PLAN EXAMINATION RFI HOLD

Maine Medical – East Tower 6 & 7th Floor Addition with Helipad

22 Bramhall St – Portland, Maine

Plans Date: 3/9/18

1 CURTAINWALL - LEVEL 6
1 1/2" = 1'-0"

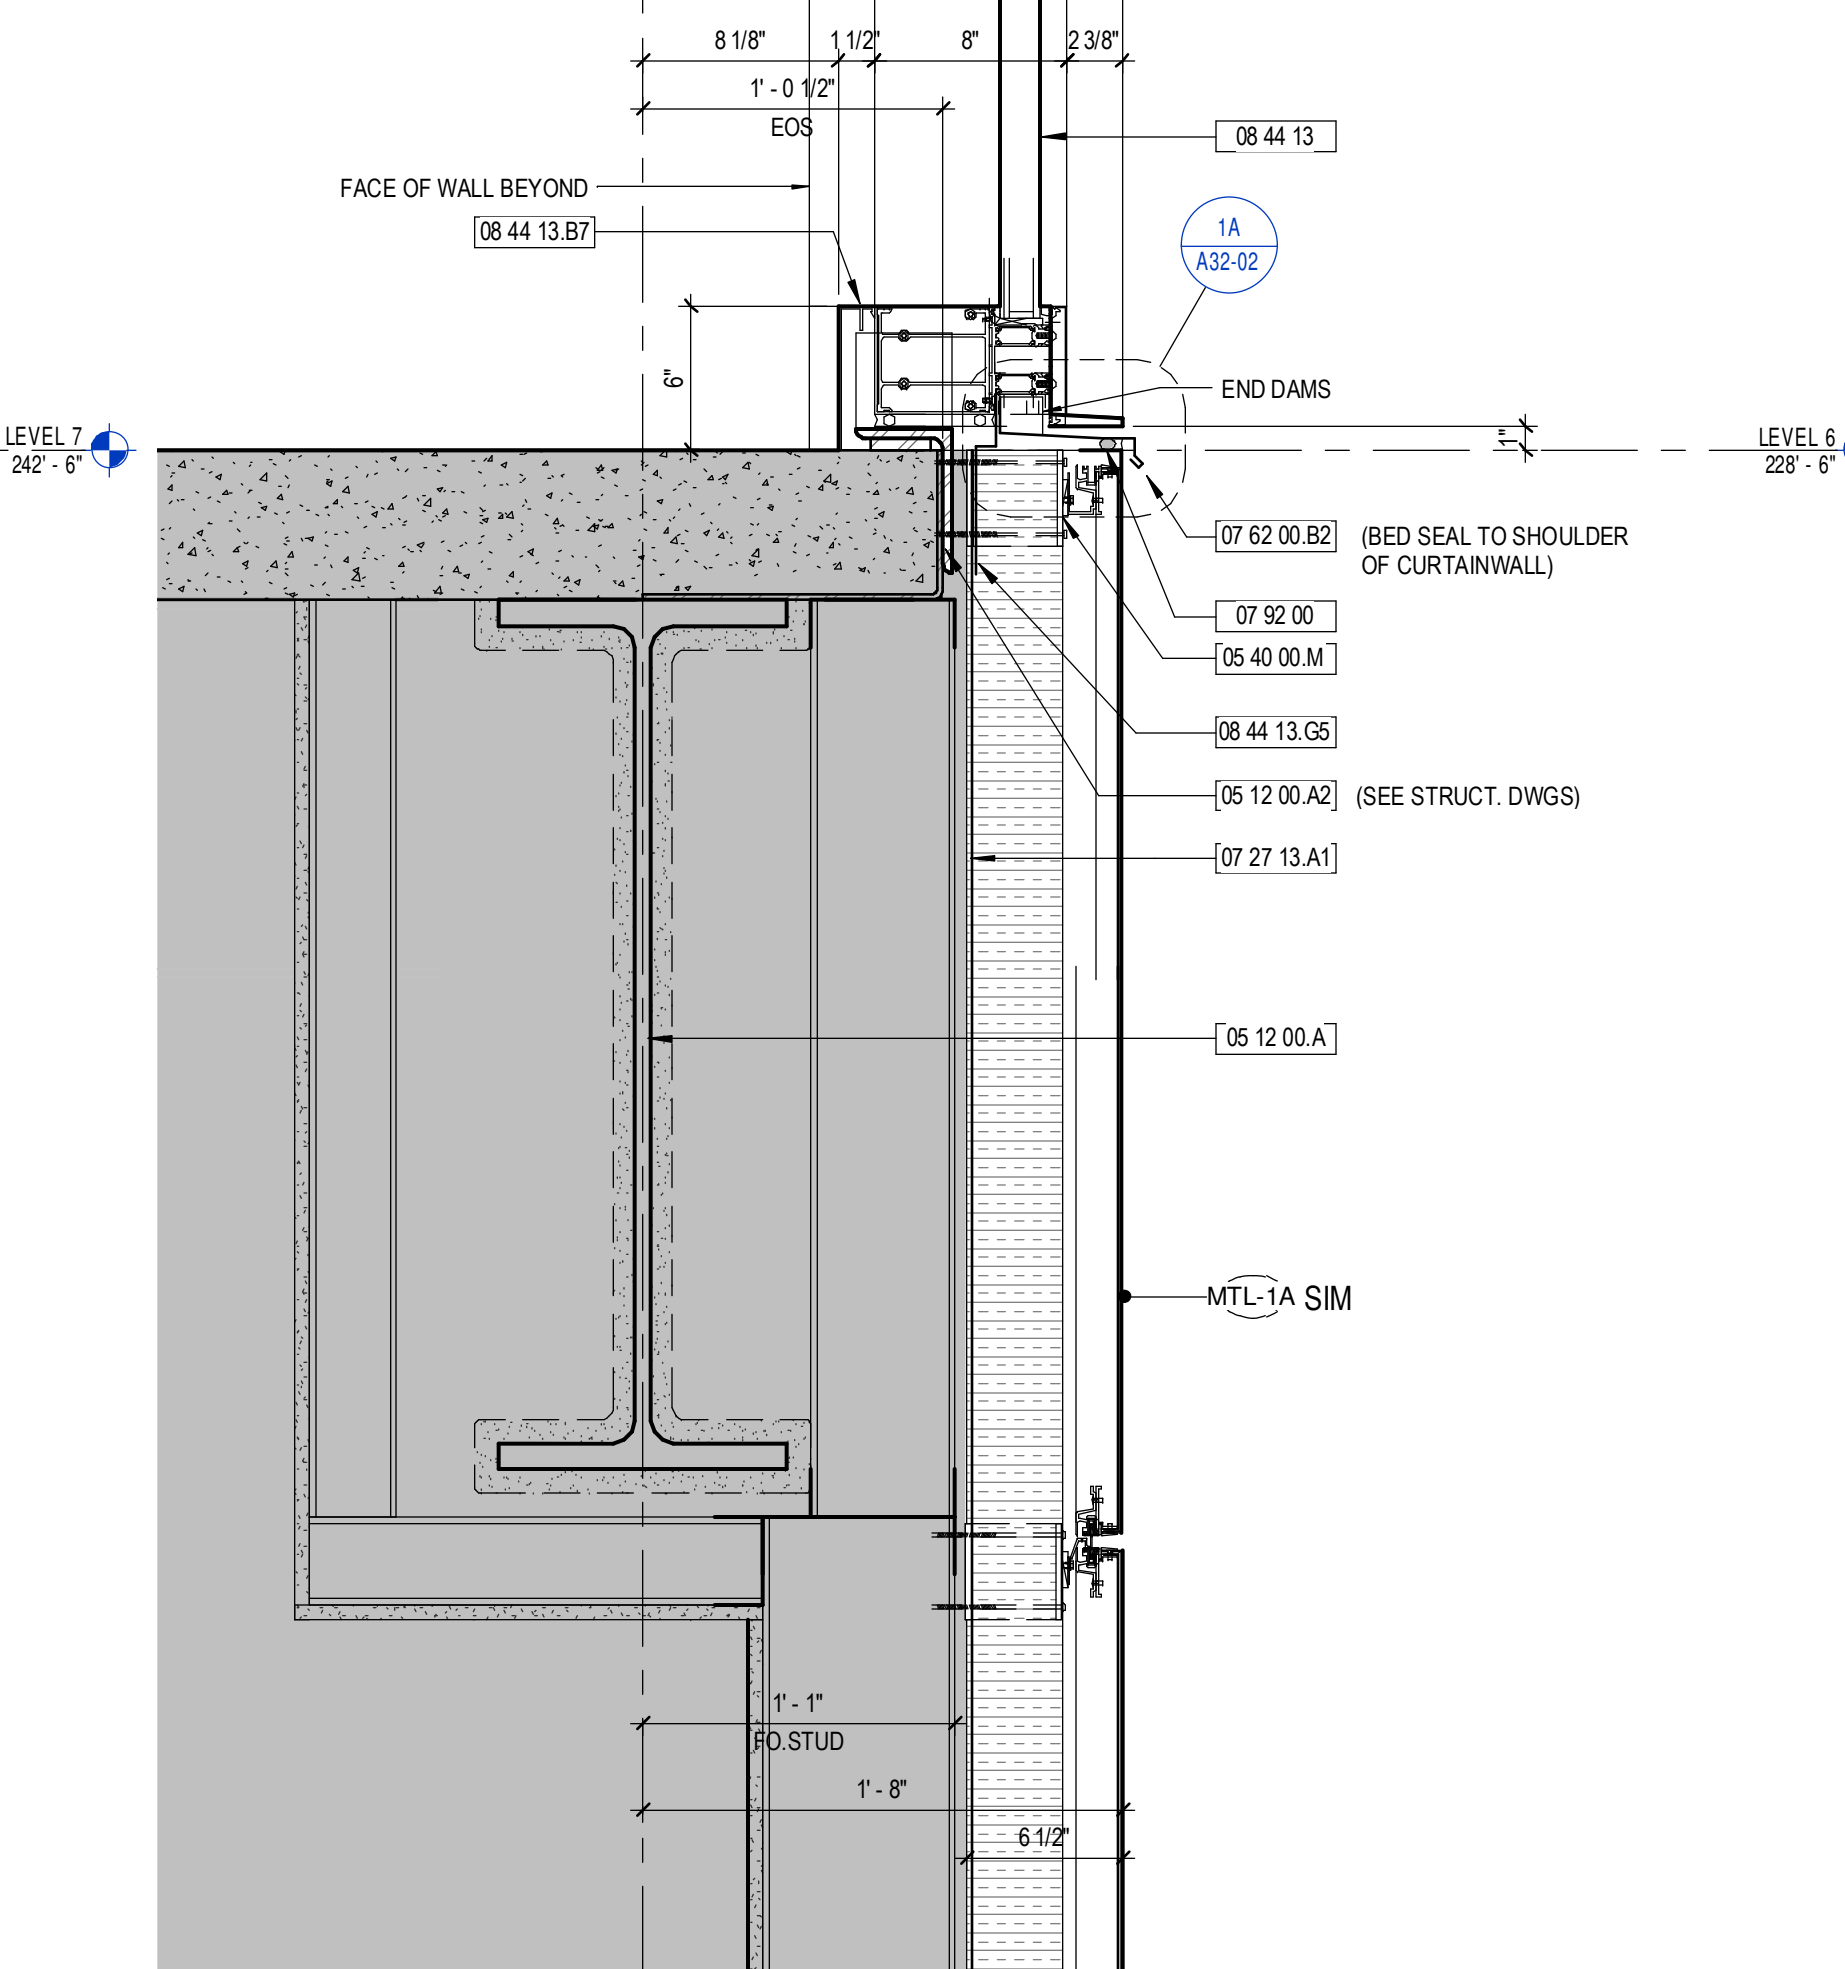
2. Provide the required fire-resistance ratings for the primary structural frame. A project code summary / analysis is not provided and the various details that show protected primary steel members (exterior section details on sheet A32-01 for example) note the protective material but do not provide a thickness or hour rating.
